Technical Note

Project No: ITB13091
Project Title: Ford Airfield – The Landings
Title: Sustainable Accessibility Addendum Note
Ref: 13091-029
Date: 5 August 2020

| DRAWN:                         | CHECKED:              | APPROVED:         |
|--------------------------------|-----------------------|-------------------|
| DRAWING No:<br>ITB13091-GA-061 |                       | REV:<br>          |

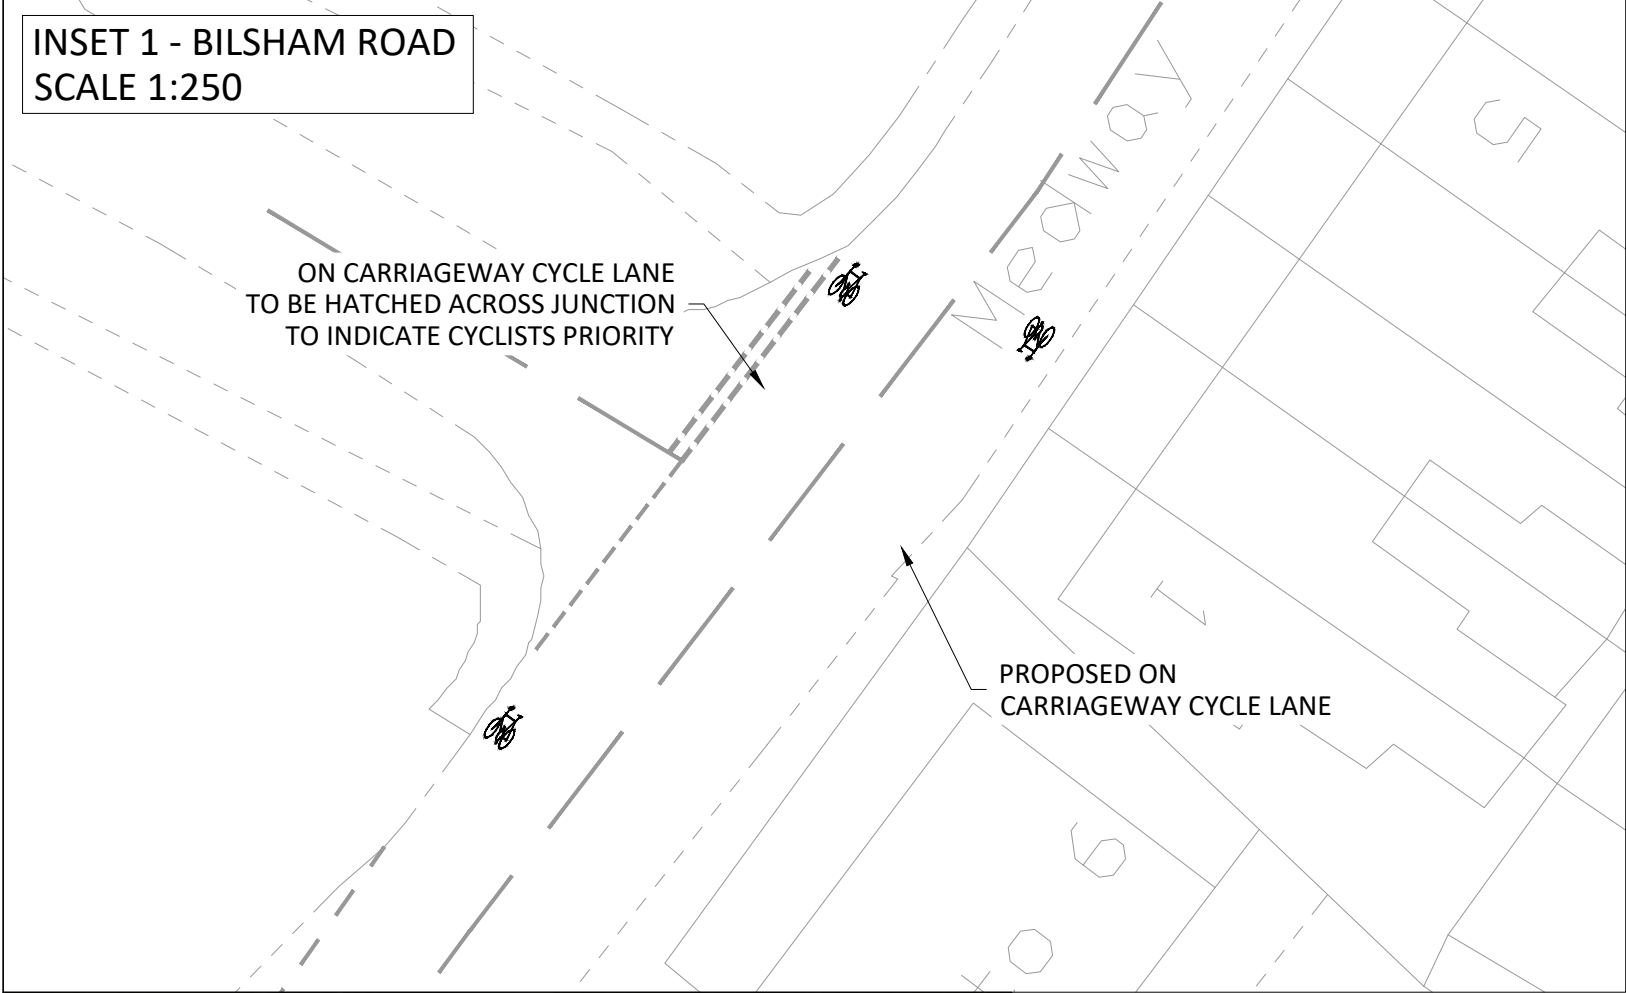
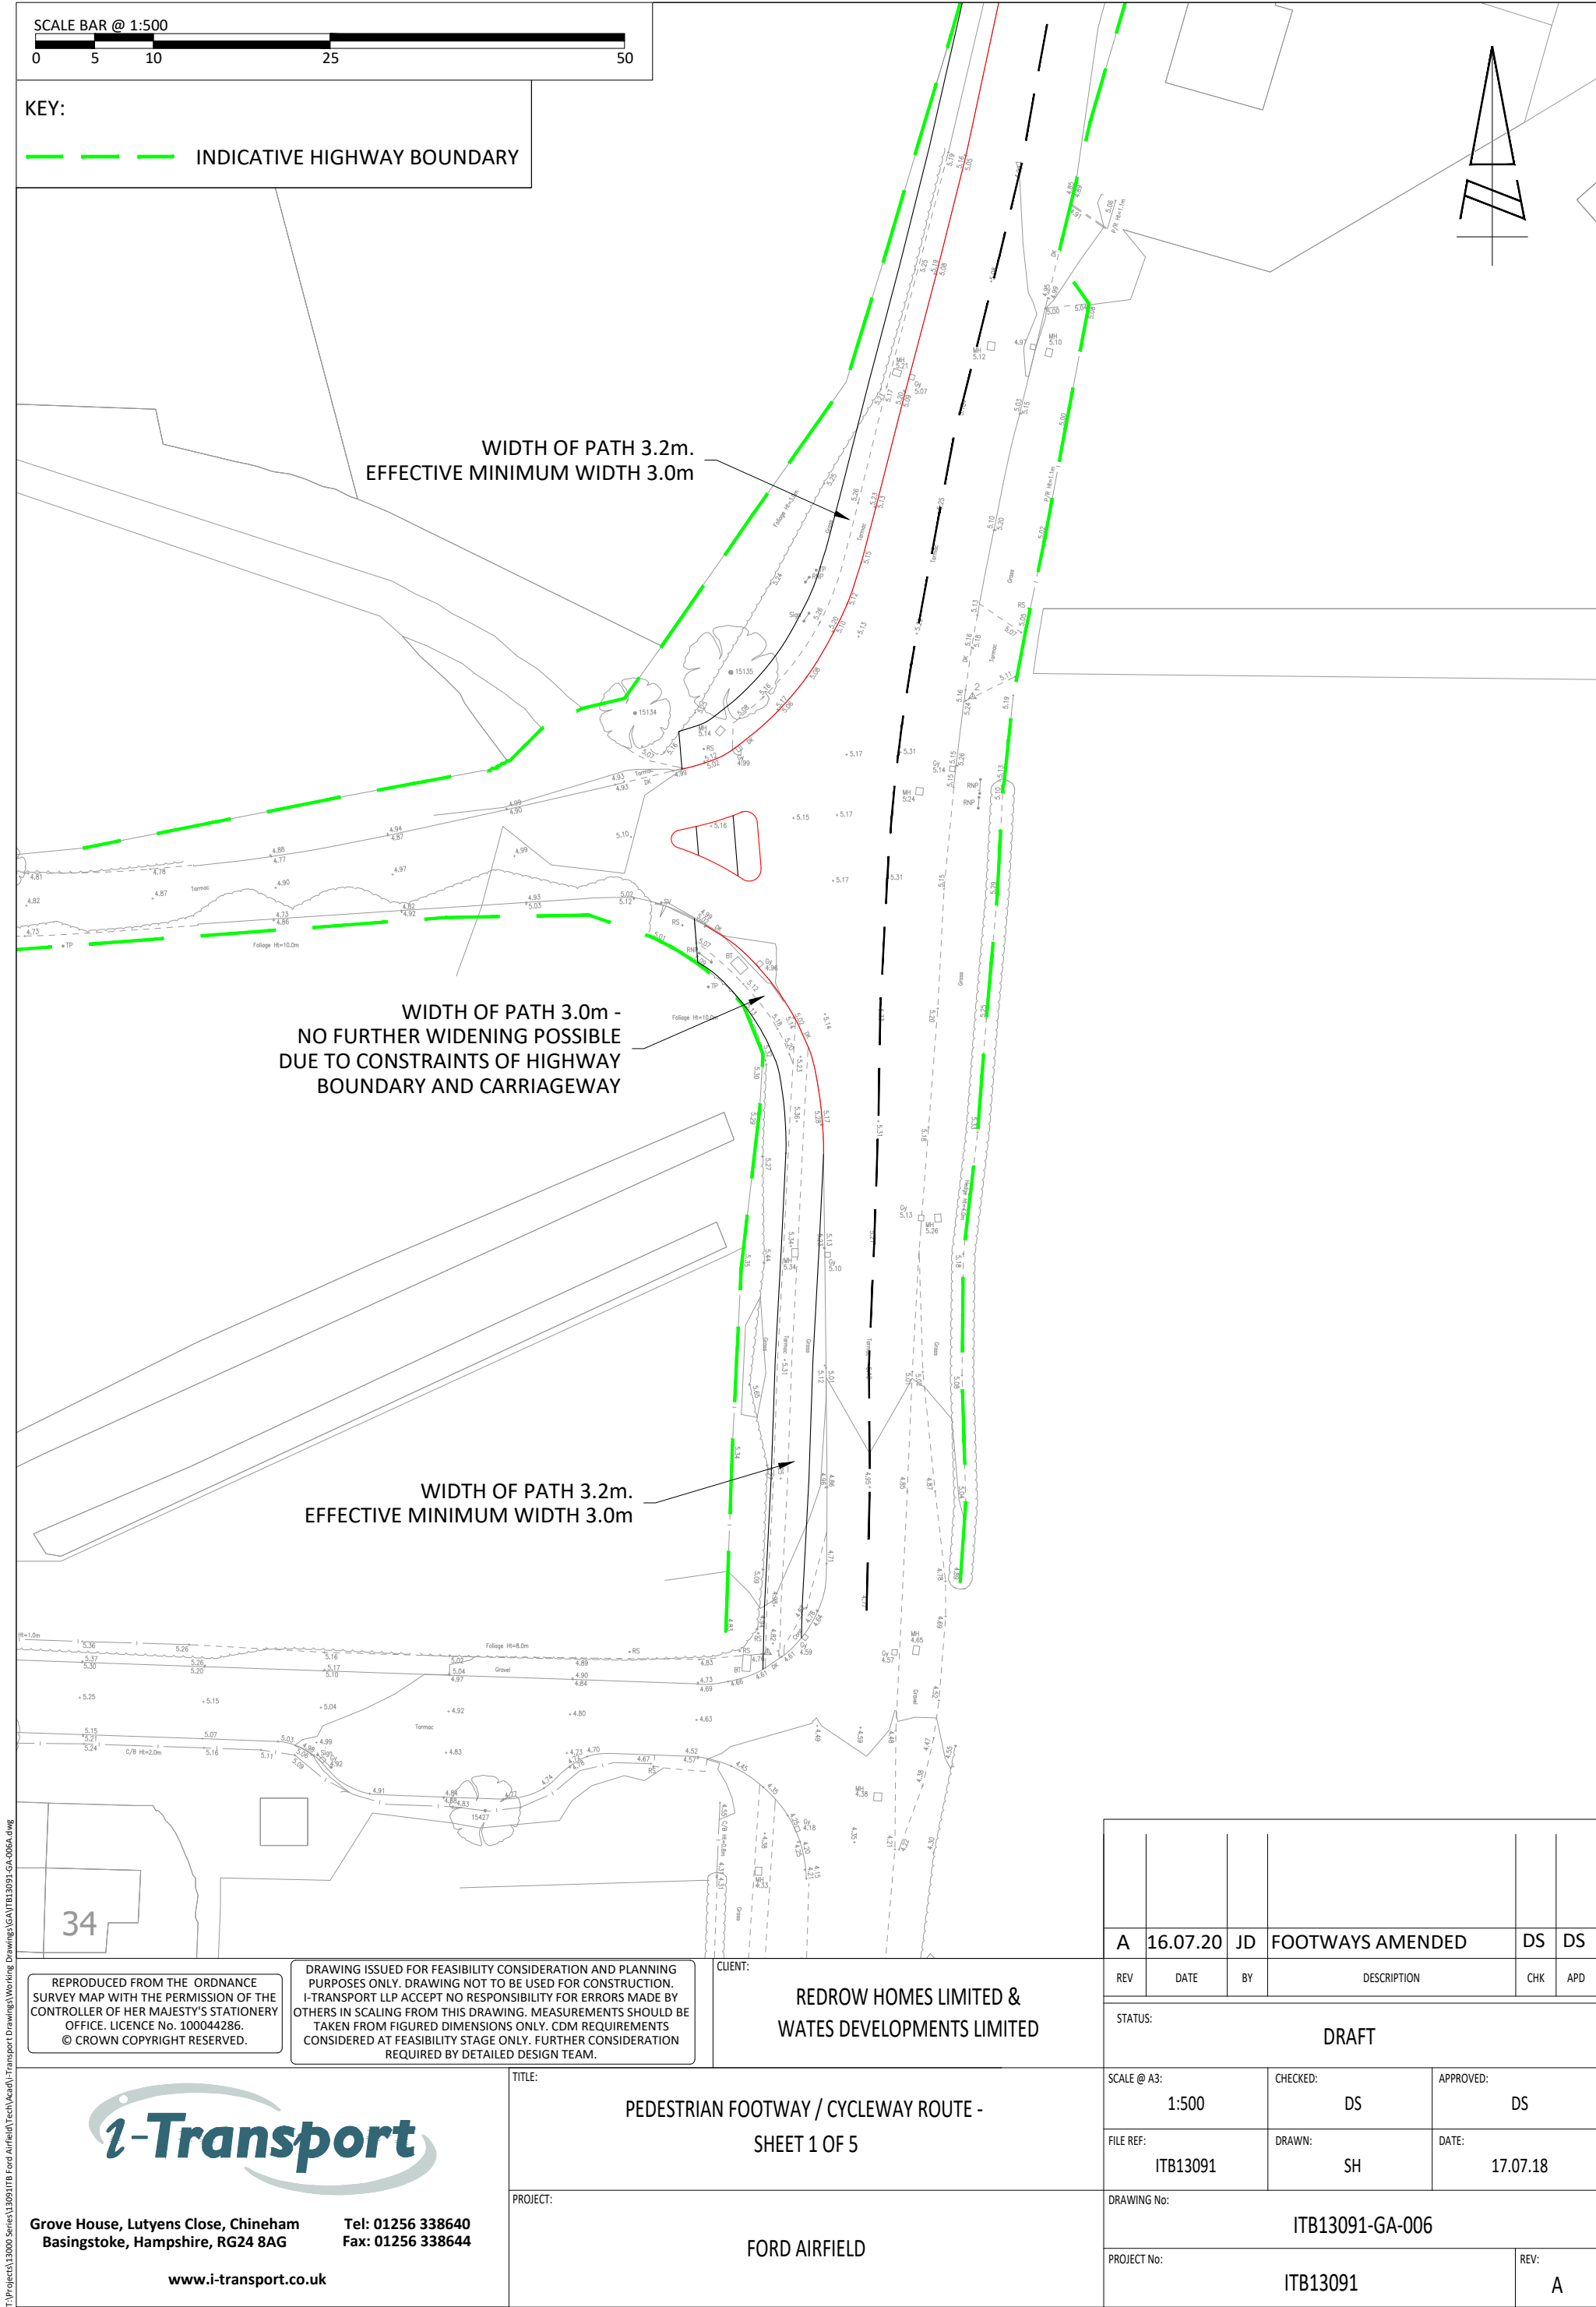
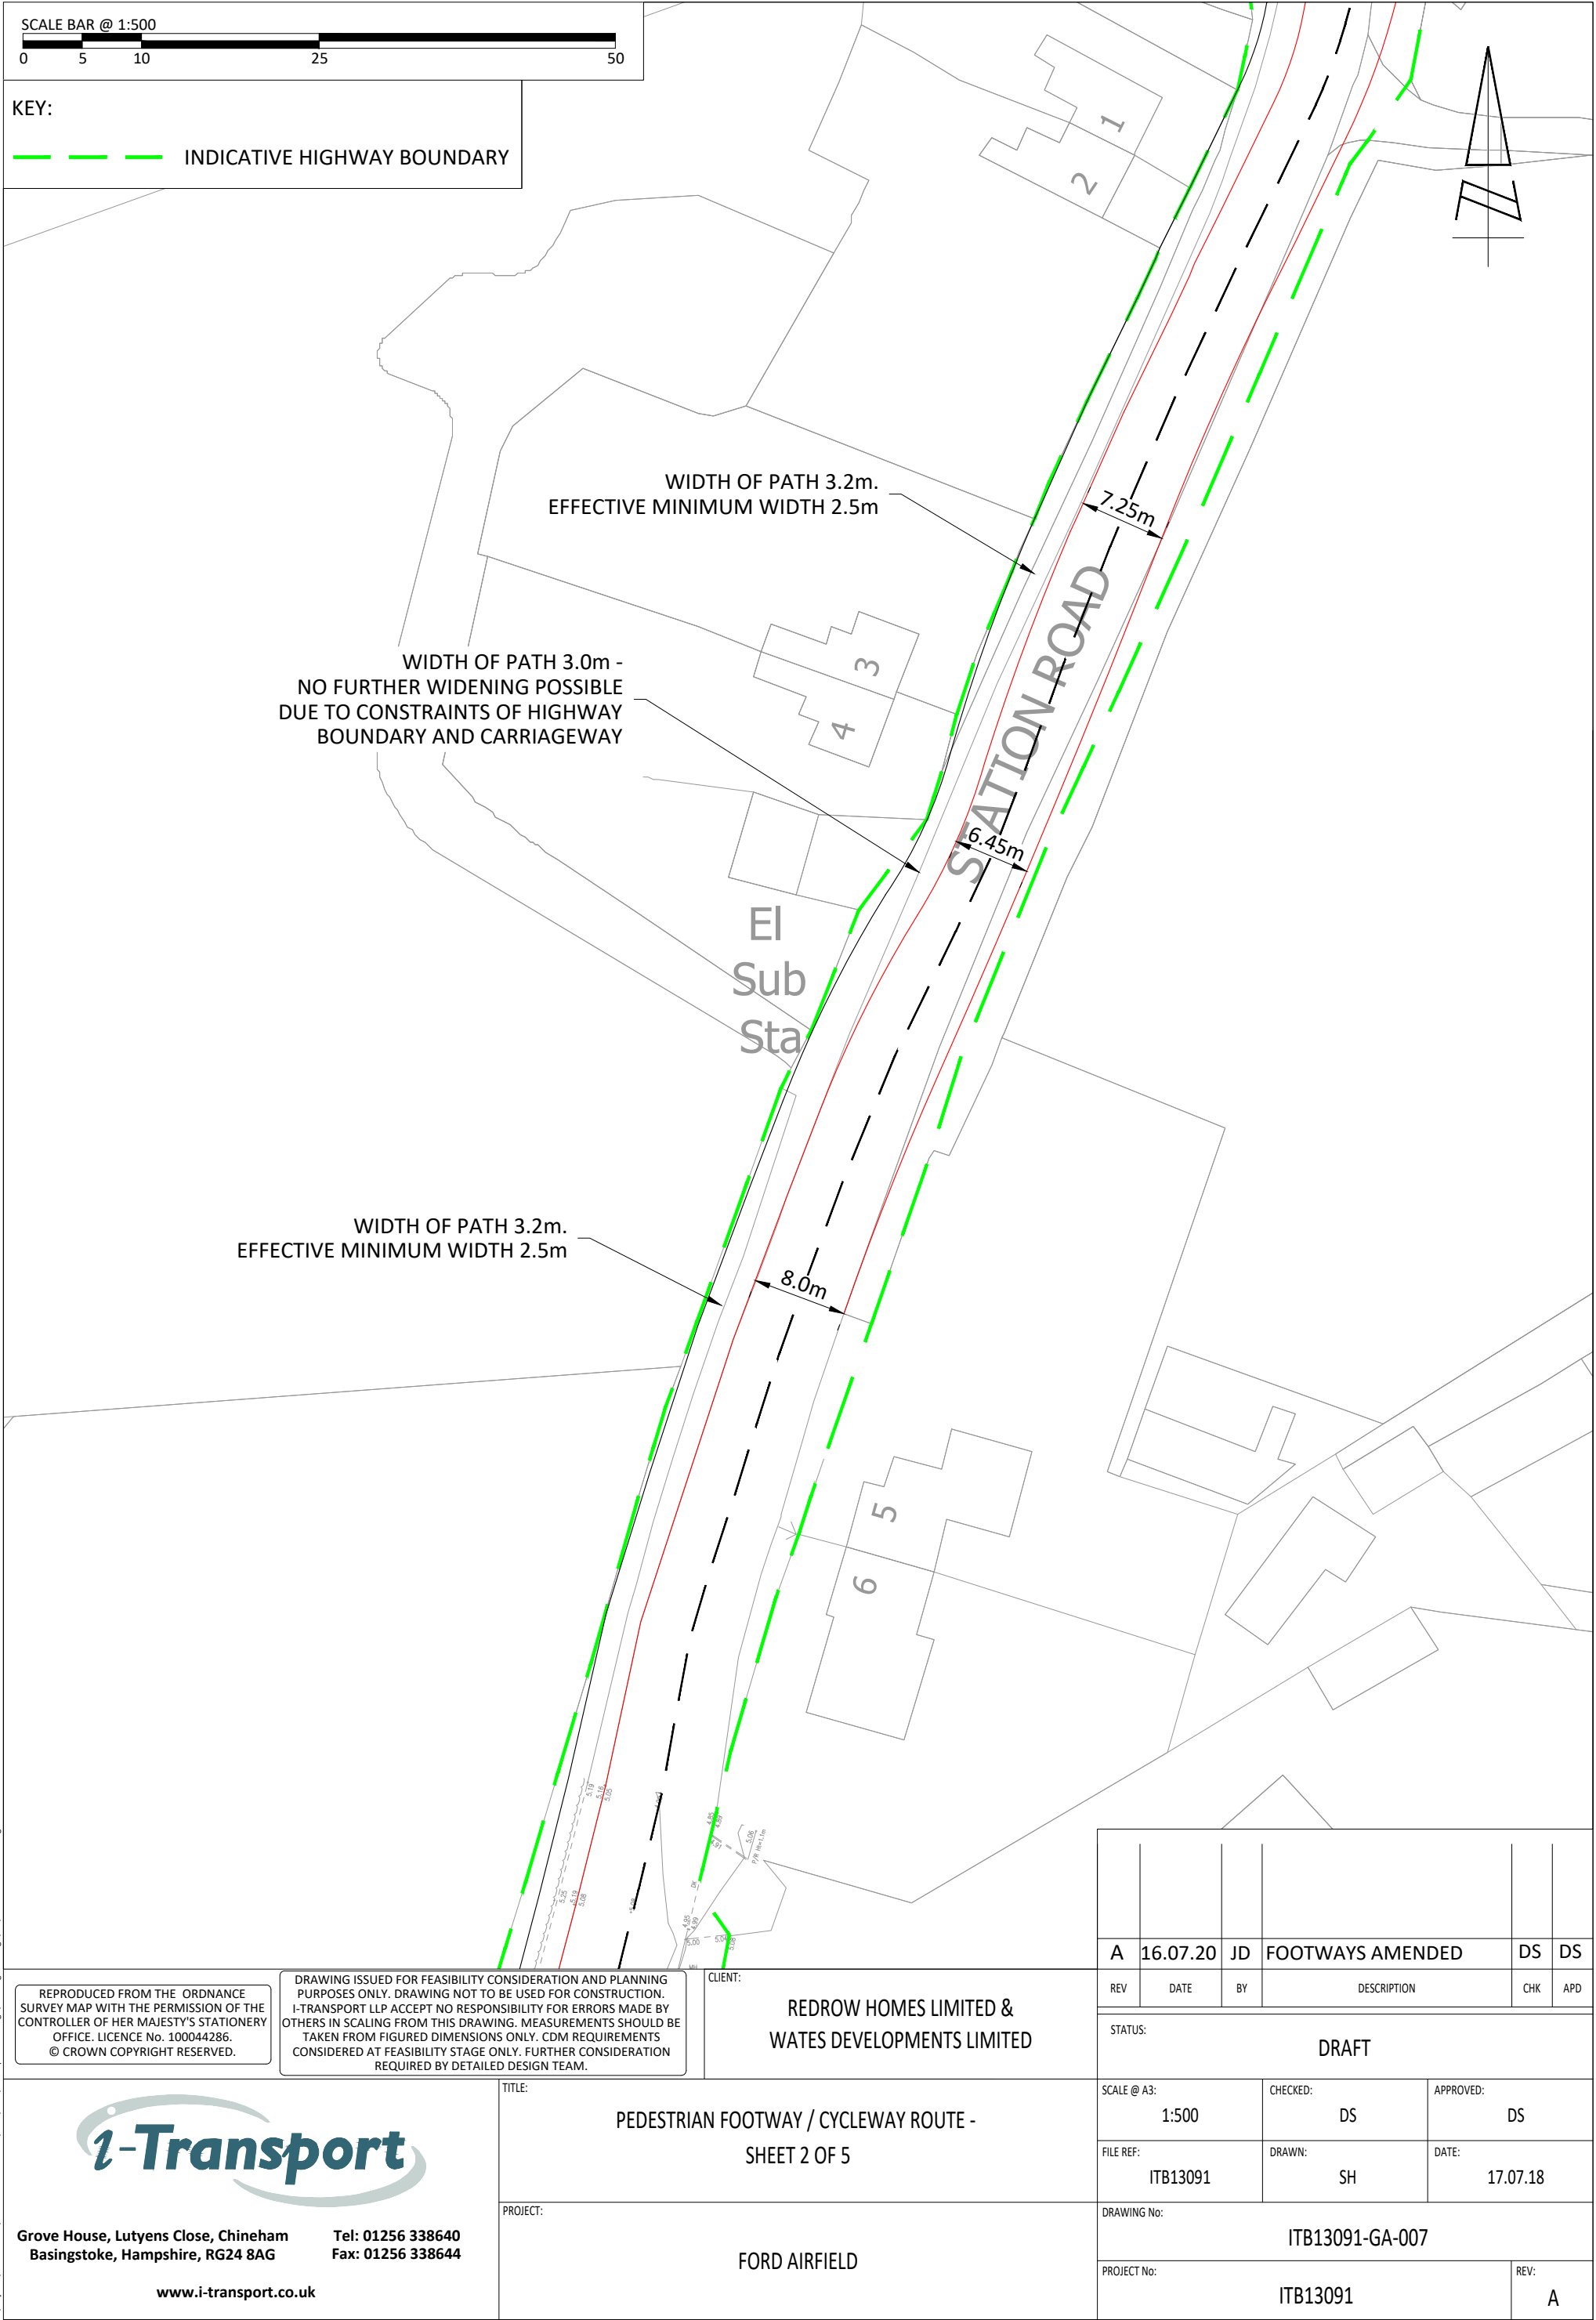
- 3.1.6 At this time no signage has been shown along the route, as the directional signage would be affected by the onwards facilities available at the time of implementation. However, an illustrative sign is shown in Drawing **ITB13091-GA-061** to define the type of signage that would be included along the route.

The signage, as well as other factors such as the location where which the route terminates (it is noted there are multiple potential routes for the Yapton-Barnham cycle route) and the intervals at which the cycle demarcation is placed, would be further refined through the detailed design process. The proposed scheme of works is intended to provide an illustrative arrangement to agree the scope of the scheme for the purposes of agreement through planning condition/S106 Agreement.
